Address: 50 Virginia Road Huddersfield HD3 4AZ

Application number: 2021/93254	
What is the application for?:	Erection of single storey rear and two storey side extension
Address of the site or building:	52, Virginia Road, Marsh, Huddersfield, HD3 4AZ
Postcode:	HD3 4AZ

Project:	VIRGINIA ROAD MARSH	Job No:	2021-021
TITLE: PROPOSED PLANS & ELEVATIONS			
Scale:	1:50@A1	Drawn by:	AP
Date:	30.06.21	Checked by:	-
Drawing No:	2021-021-(20)002	Revision No:	-

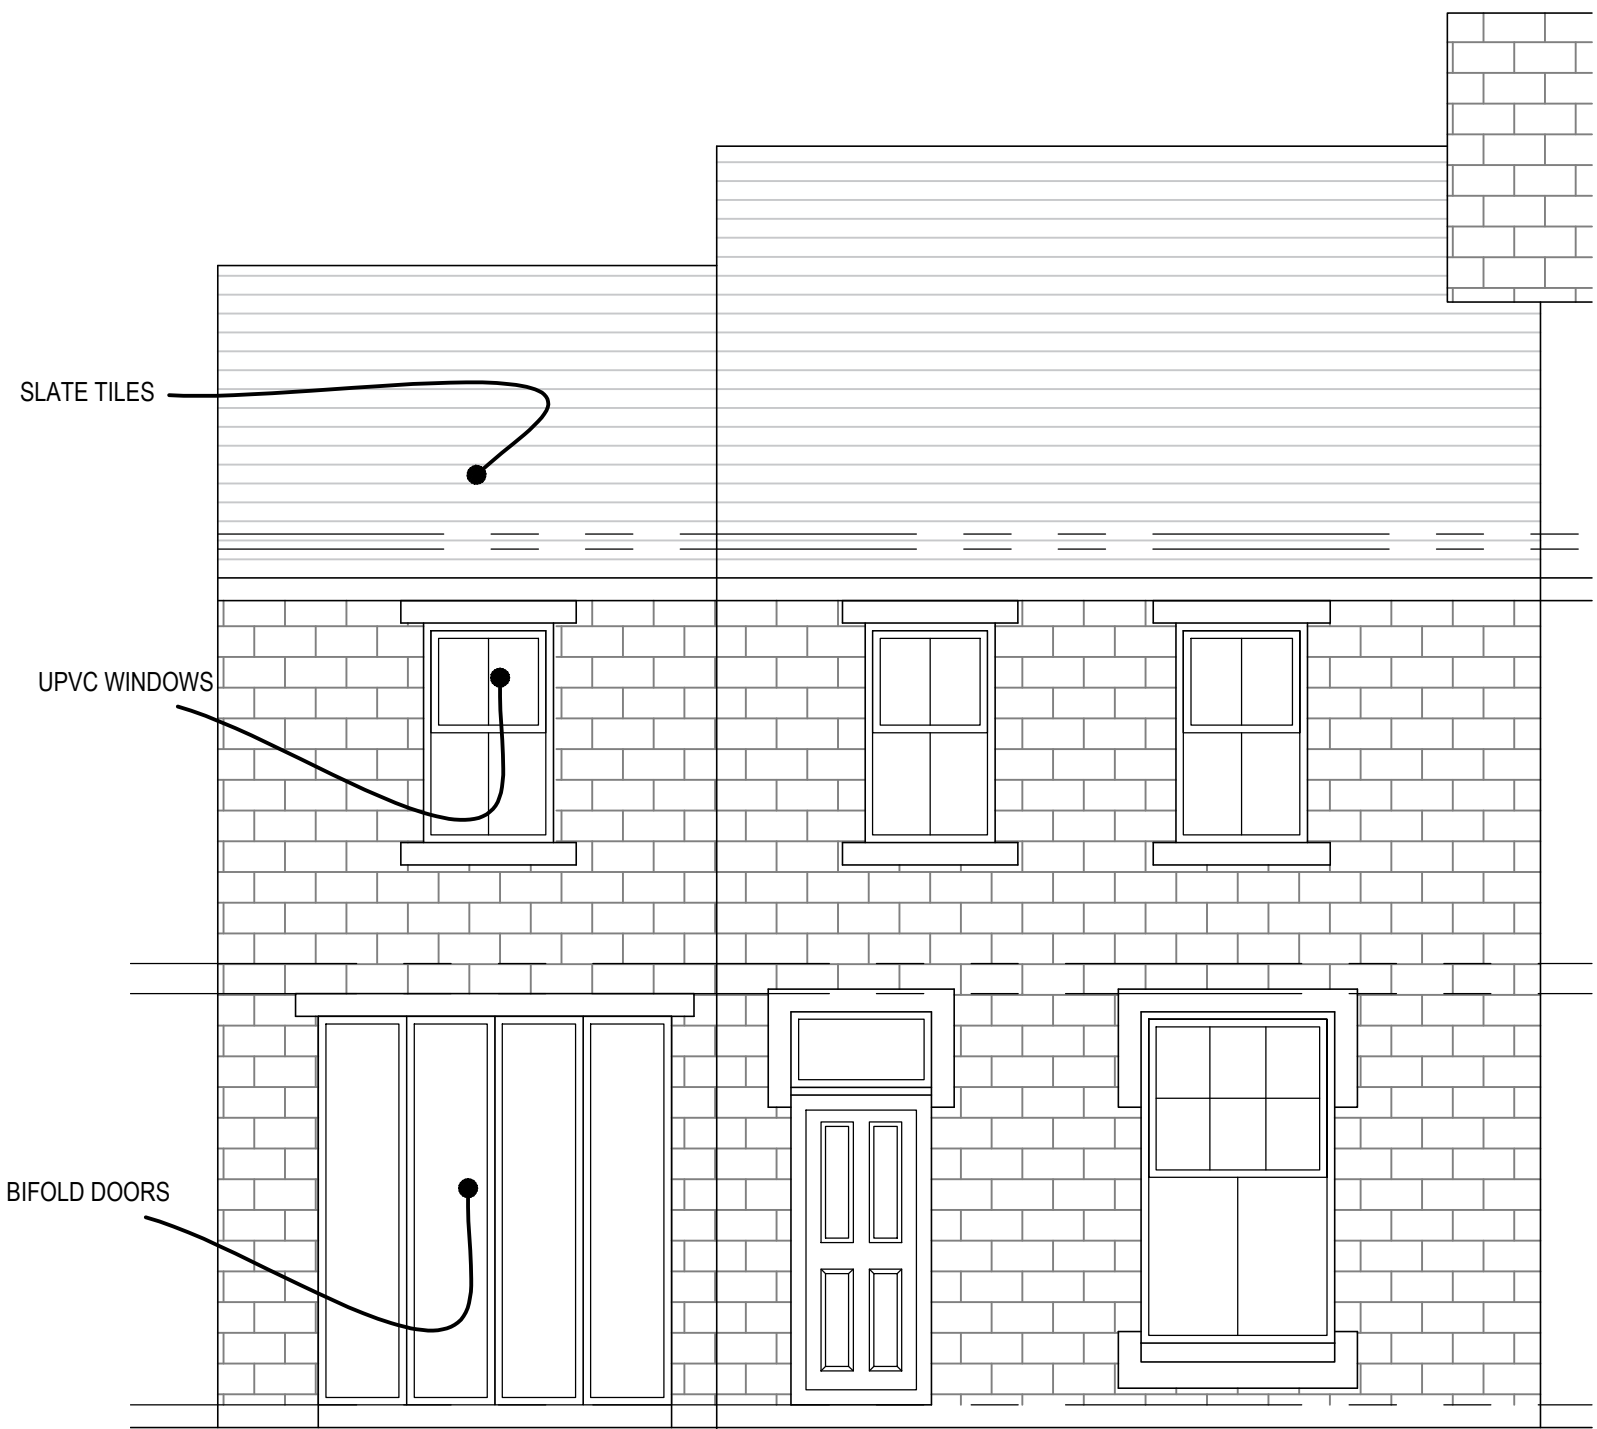
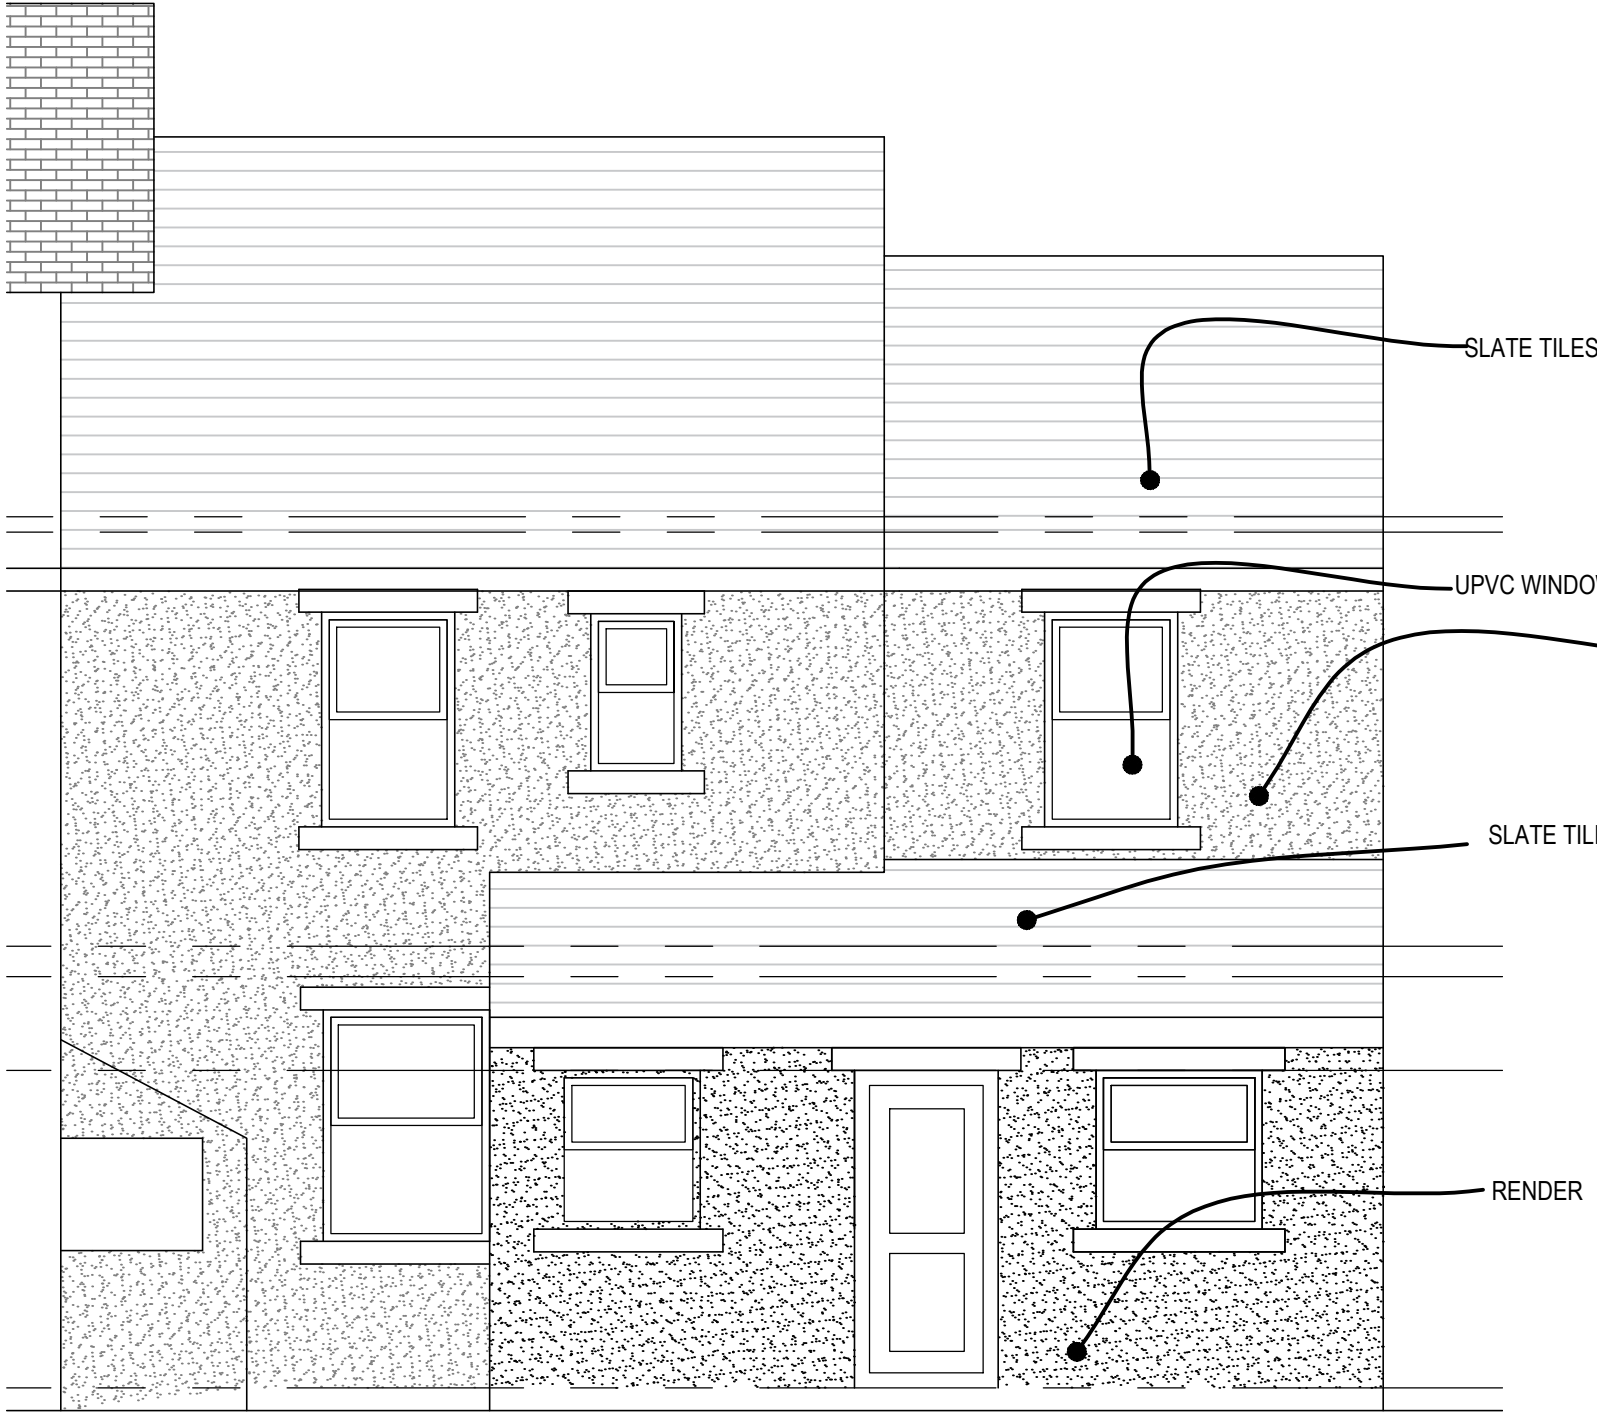
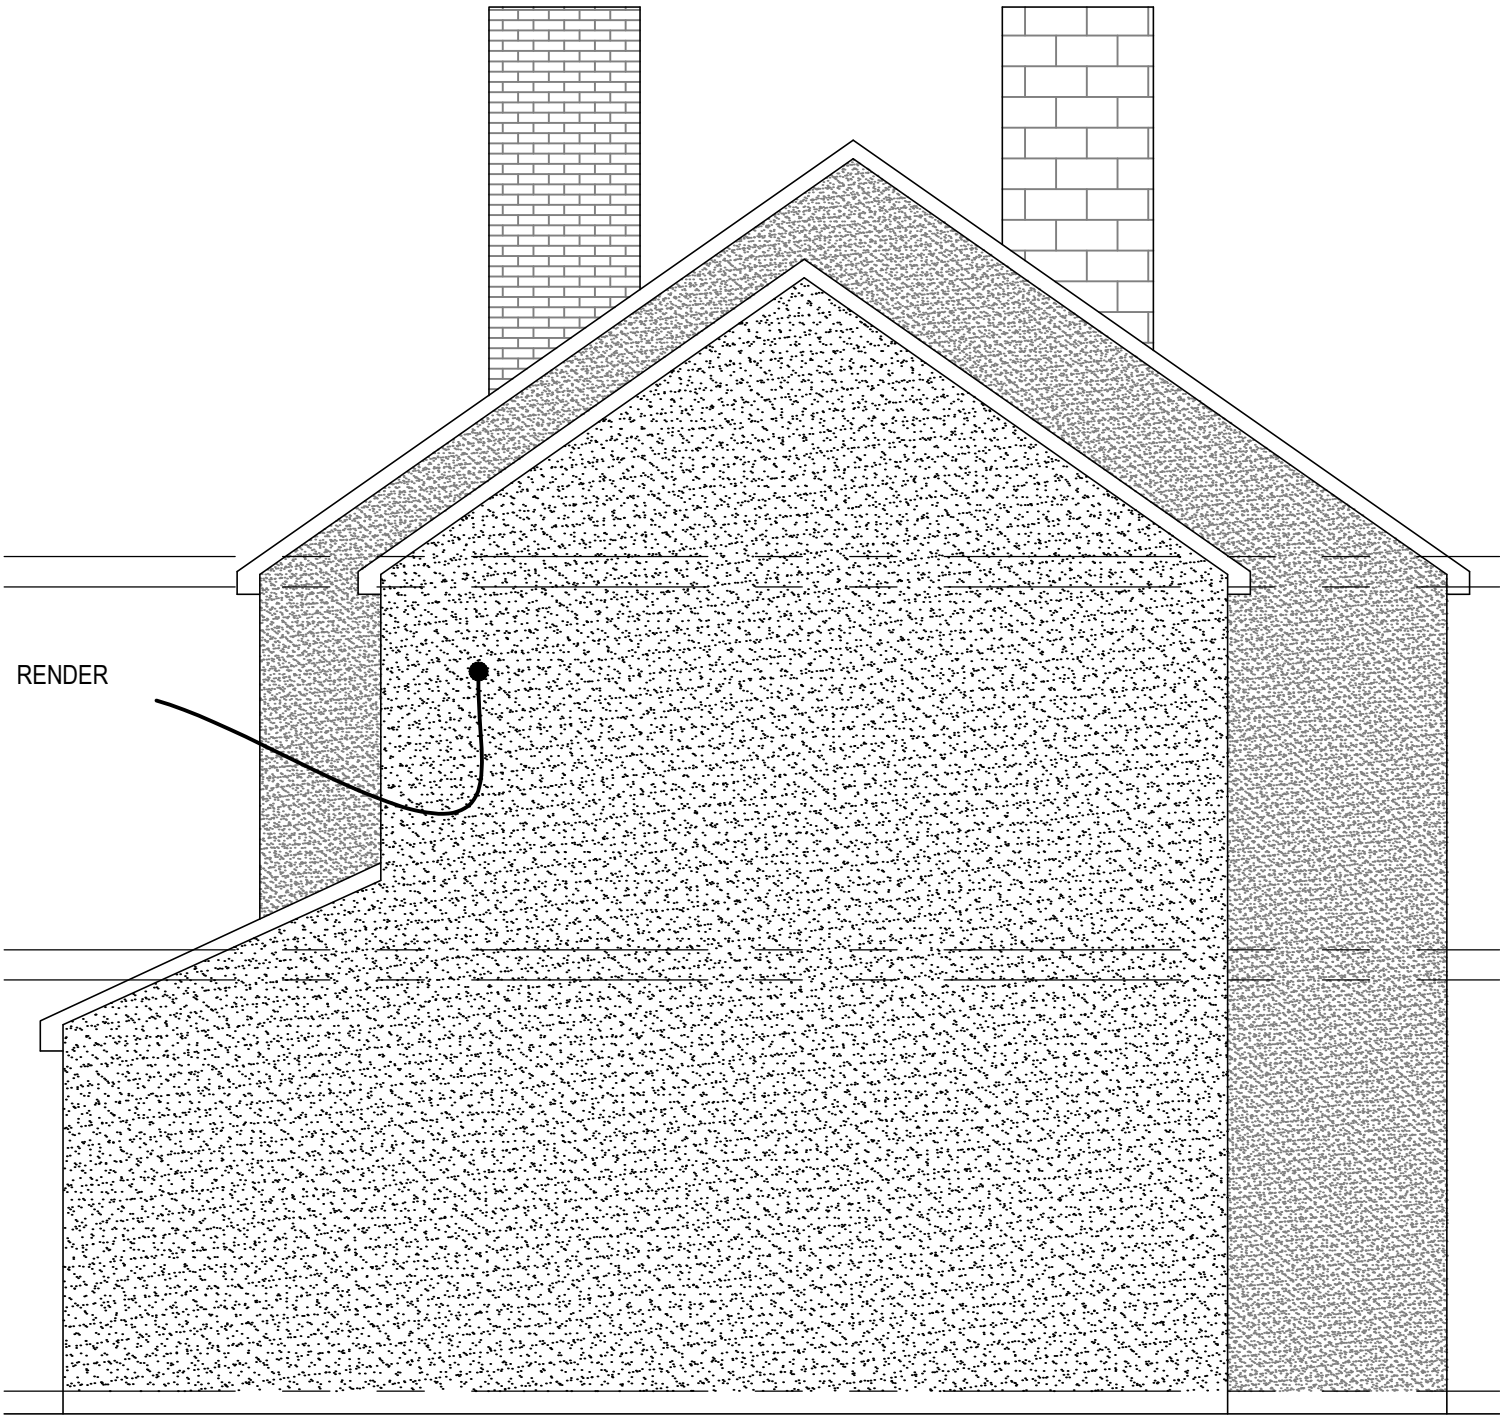
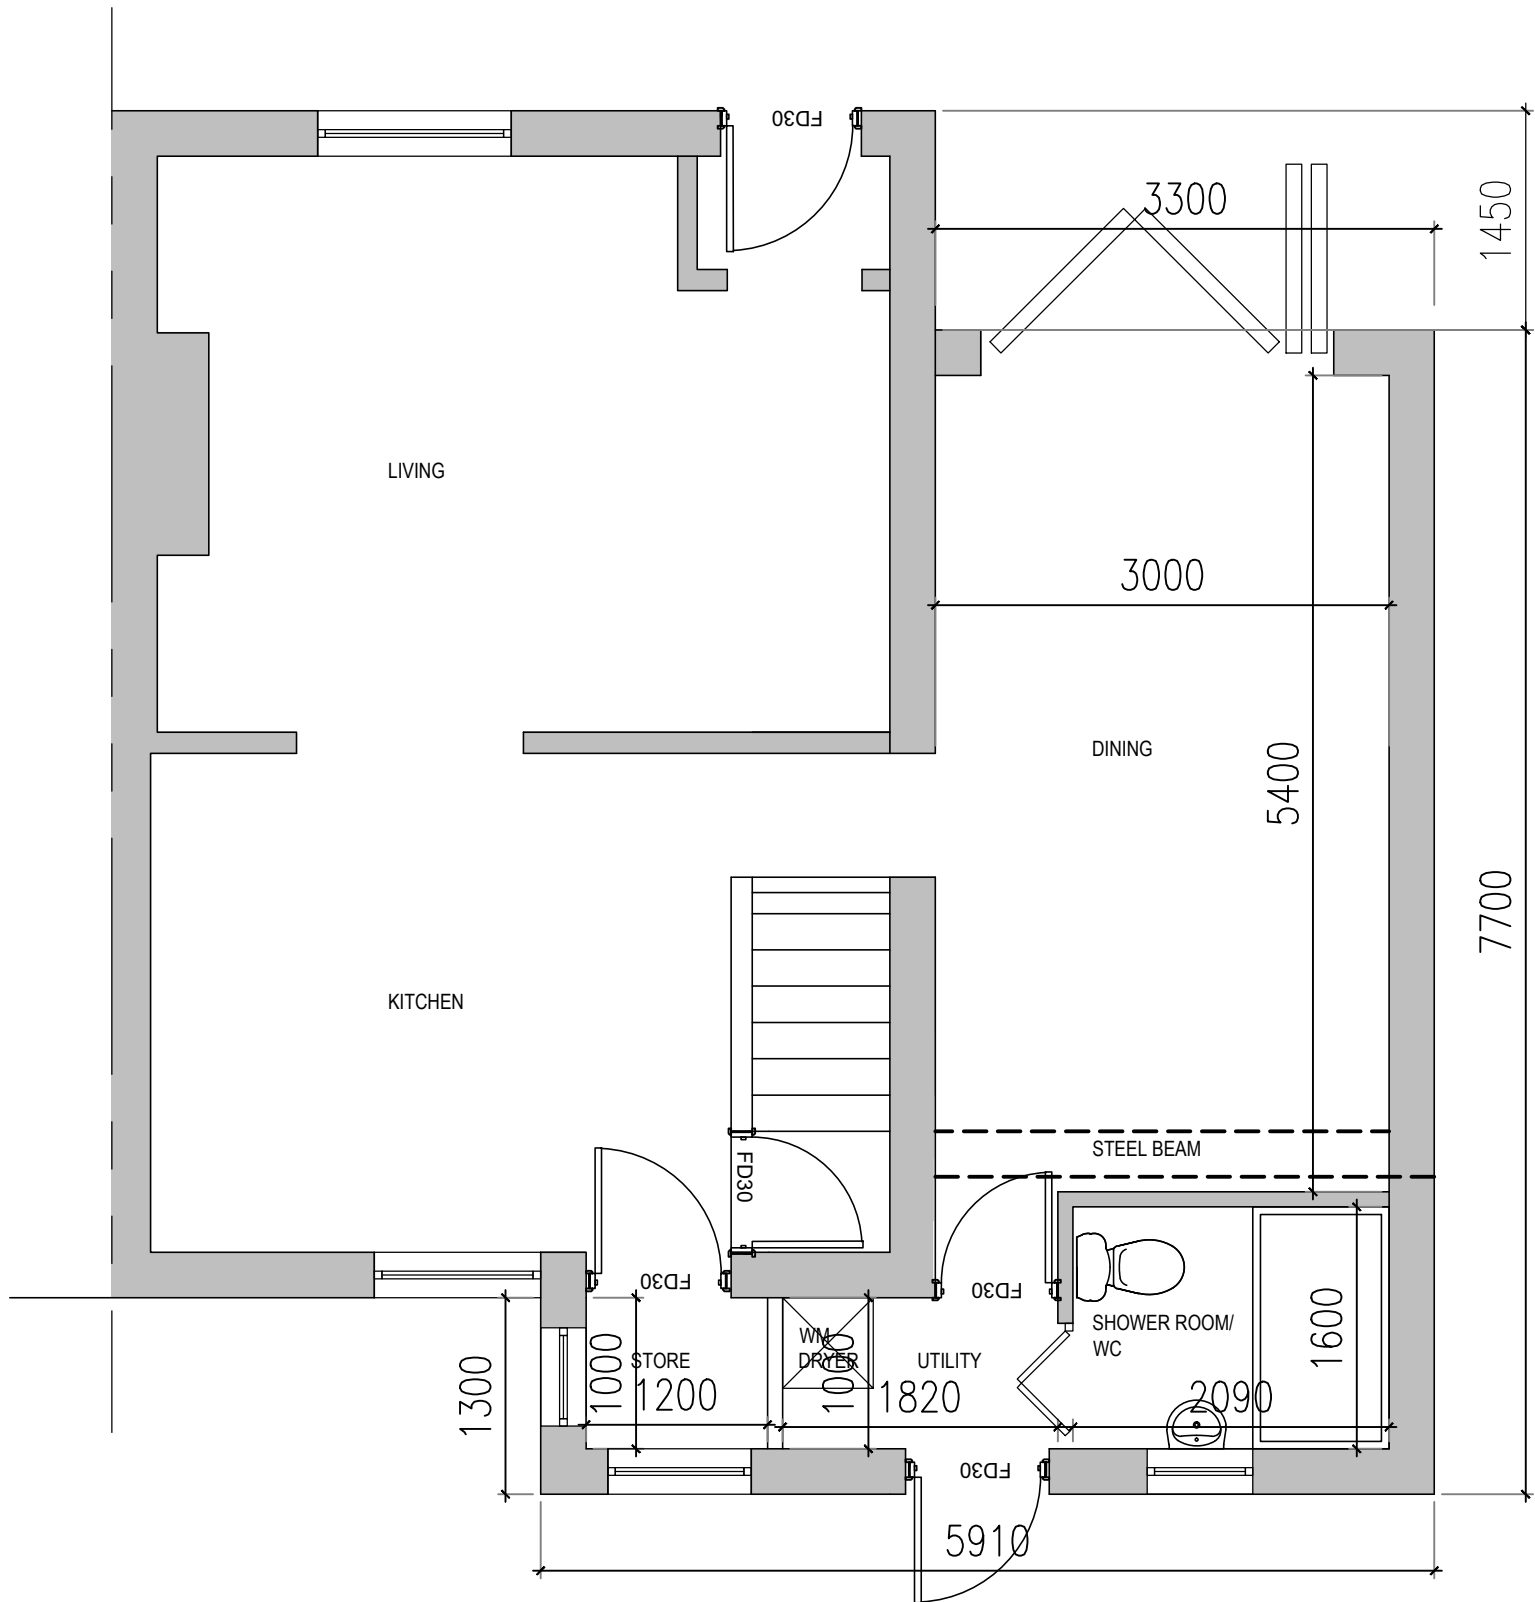
Type of comment: A general comment	
Do you wish your comments to be published on the website anonymously?	No
Doc 8899007 existing, the outside shed is visible. On proposed rear elevation shed is also visible. doc 889906 Proposed ground rear, shed is not visible. Also is not visible on proposed site block plan. This is a shared brick shed. I want assurances the shared shed will not be touched. On householder application page re trees; applicant has answered 'no' to tree or hedges within falling distance of 52 Virginia rd ,however there is a large sycamore tree on the property ,at the rear of 52 Virginia rd.
